LANDSCAPE AND VISUAL REVIEW
OF THE DEVELOPMENT CONSENT ORDER (DCO) APPLICATION
FOR THE SPRINGWELL SOLAR PROJECT
FOR
LINCOLNSHIRE COUNTY COUNCIL
&
NORTH KESTIVEN DISTRICT COUNCIL

May 2025

Landscape and Visual Review

TITLE:
Figure 16.3: Cumulative ZTV – Springwell and National Grid Navenby Substation

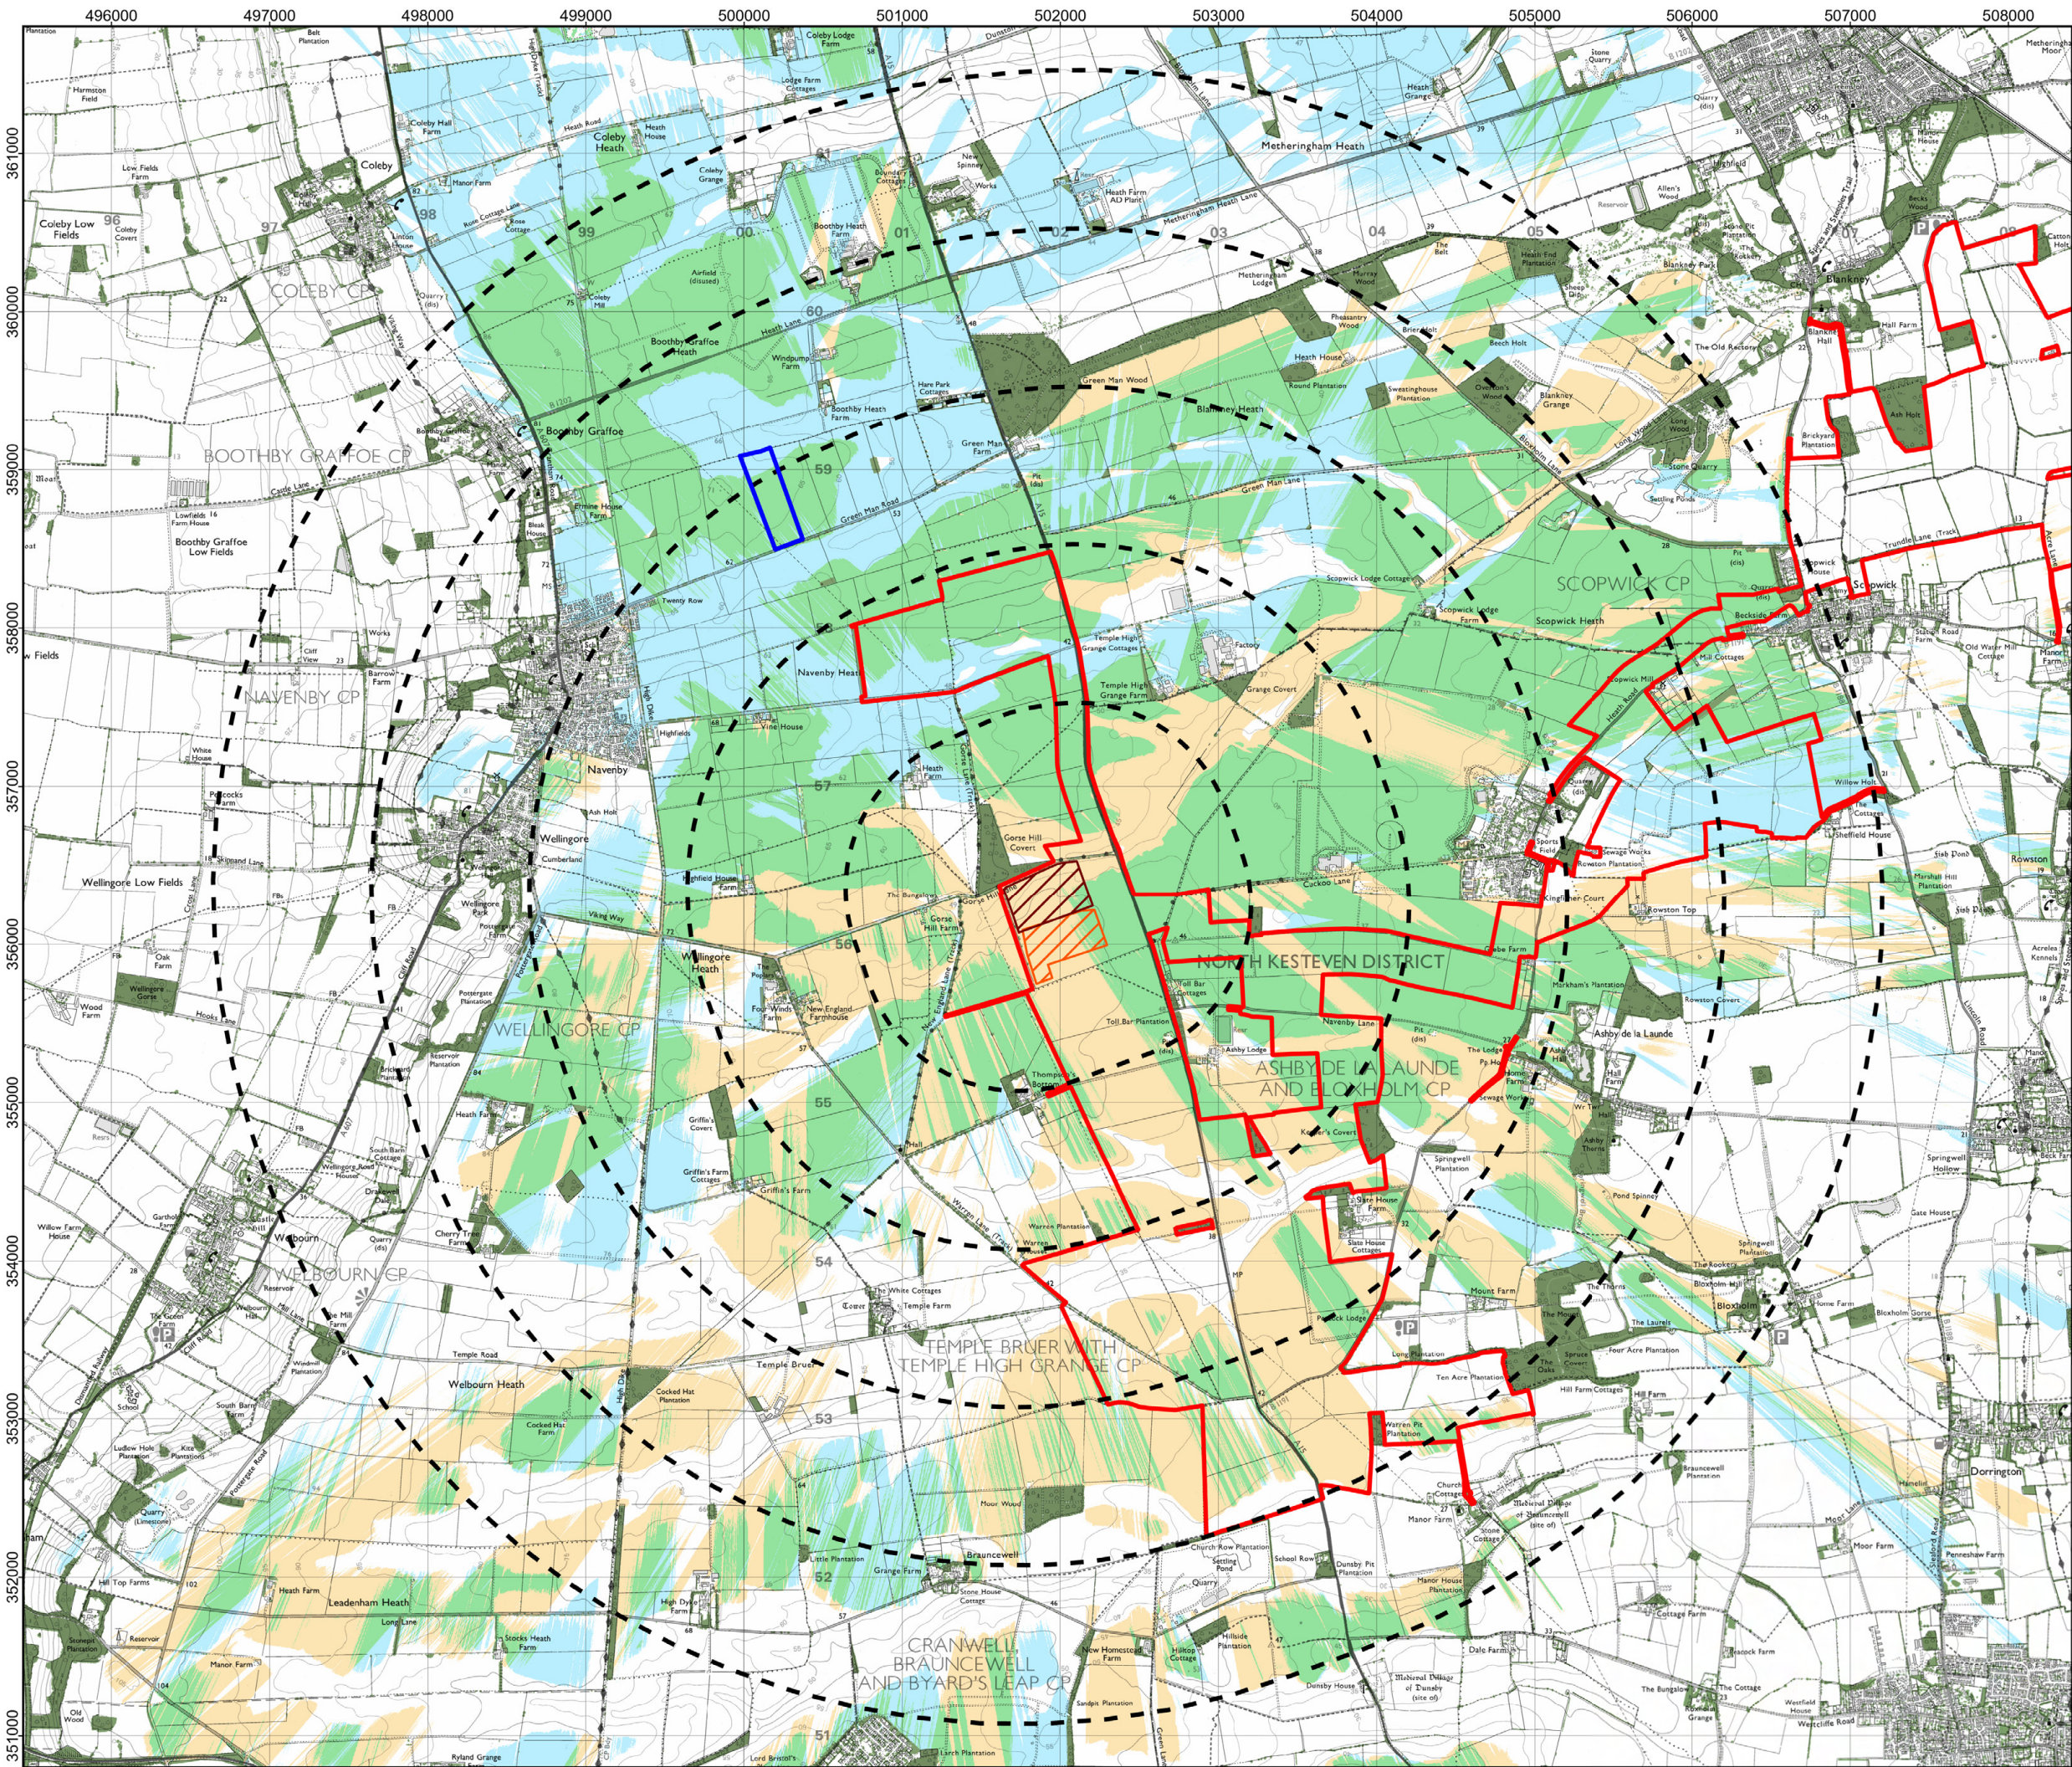
- 6.4 National Grid Navenby Substation is identified as the primary project to potentially generate cumulative landscape or visual effects with Springwell Solar Farm. Subsequently Significant cumulative effects are identified through extending the overall area of development, increasing the land use area changed from agricultural to energy infrastructure, and also visually through increasing the extent the two schemes may likely be visible by receptors.

- 6.5 We note that para. 16.6.41 states that *“No further additional mitigation has been proposed to mitigate inter-project cumulative effects between the two developments.”* However, there are potential opportunities for the applicants of each scheme to coordinate mitigation planting in the area around the National Grid Substation, which we would recommend are investigated further if possible. For example, this may include the extending of carriageway hedgerow planting further north along the western edge of the A15 (such as along field parcels Bcd024, Bcd027, Bcd031), which are in the Springwell Order Limits and would bring mitigation planting closer to potential visual receptors, likely further screening the proposed National Grid Substation.

TITLE:
Figure 16.5: Cumulative ZTV – Springwell and RAF Digby Development

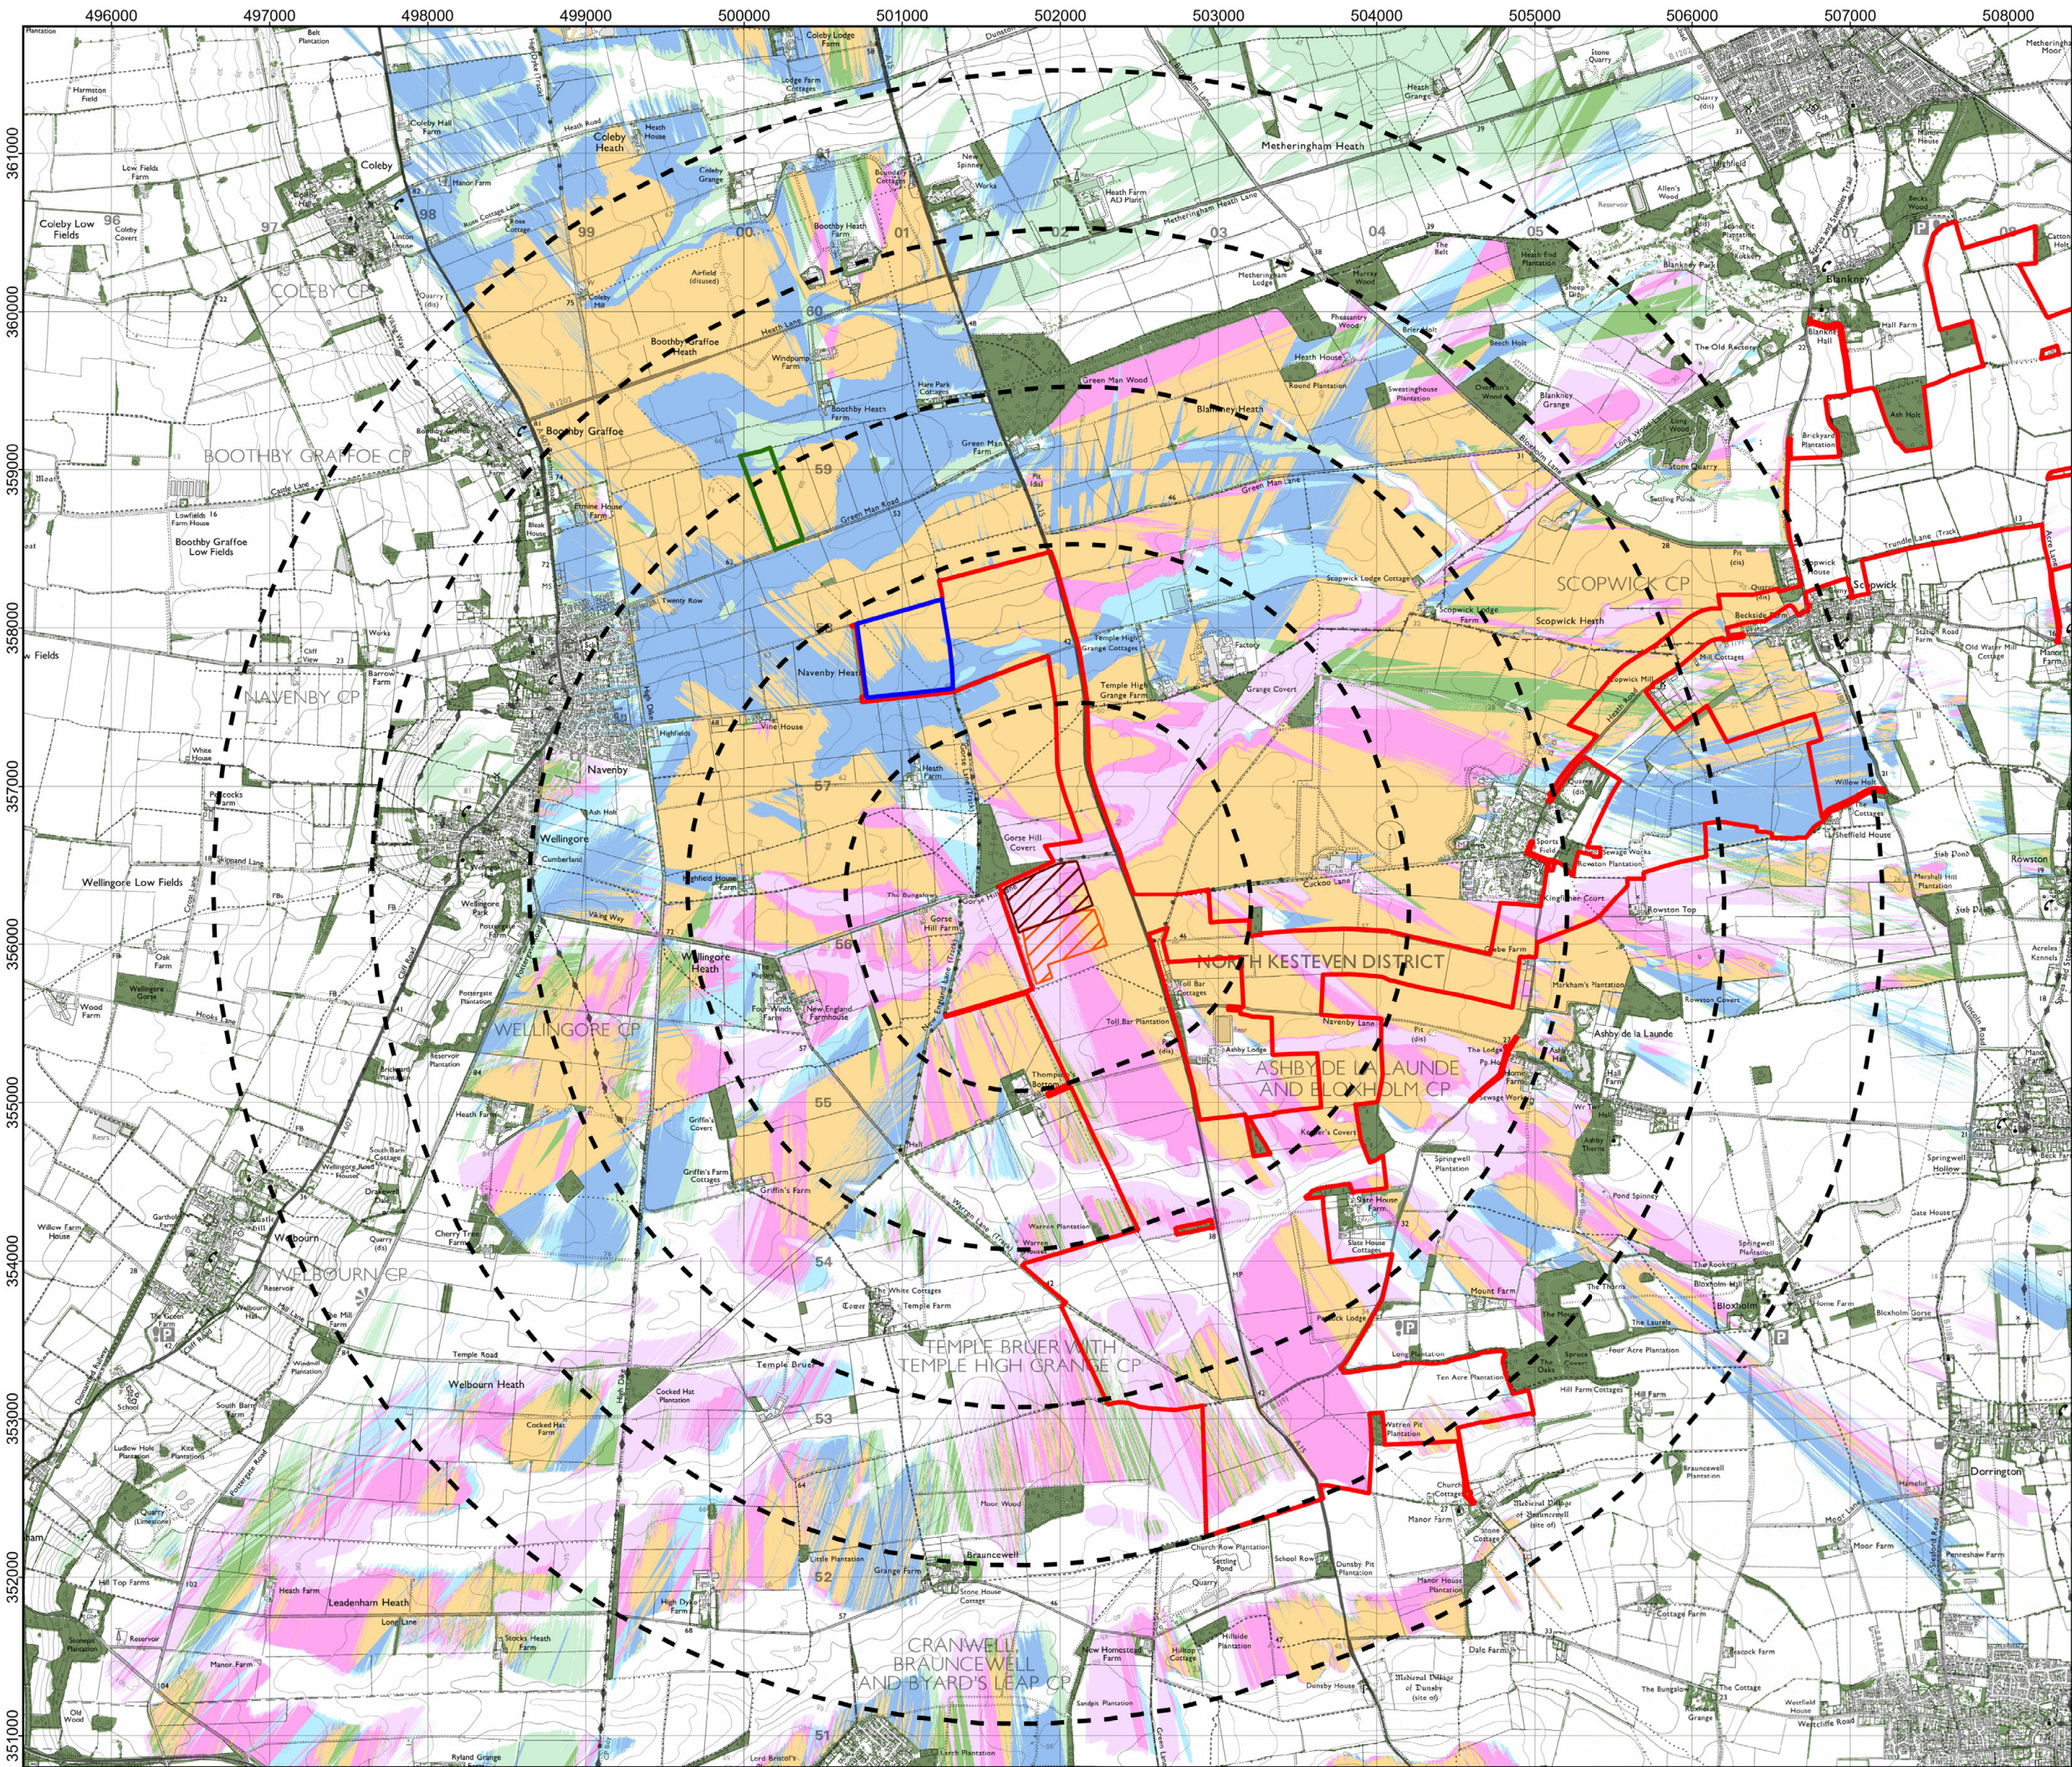
- 6.6 We would also expect that landscape and visual cumulative effects would be likely from:
- 23/0390/EIA SCO Town and Country Planning Act 1990 Navenby Heath 400 Megawatt (MW) Battery Storage Development 2km north west; and

- 24/0959/FUL Town and Country Planning Act 1990 RAF Digby Proposed office and training building Adjacent to Order Limits/within Order Limits.

Table 16.11 identifies cumulative effects from these two schemes, with further detail provided from paragraph 16.7.48. However the LVIA identifies in paragraph 16.7.55 that *“No significant inter-project cumulative effects have been identified and therefore it is considered that there is no additional mitigation is required above what is described”*.
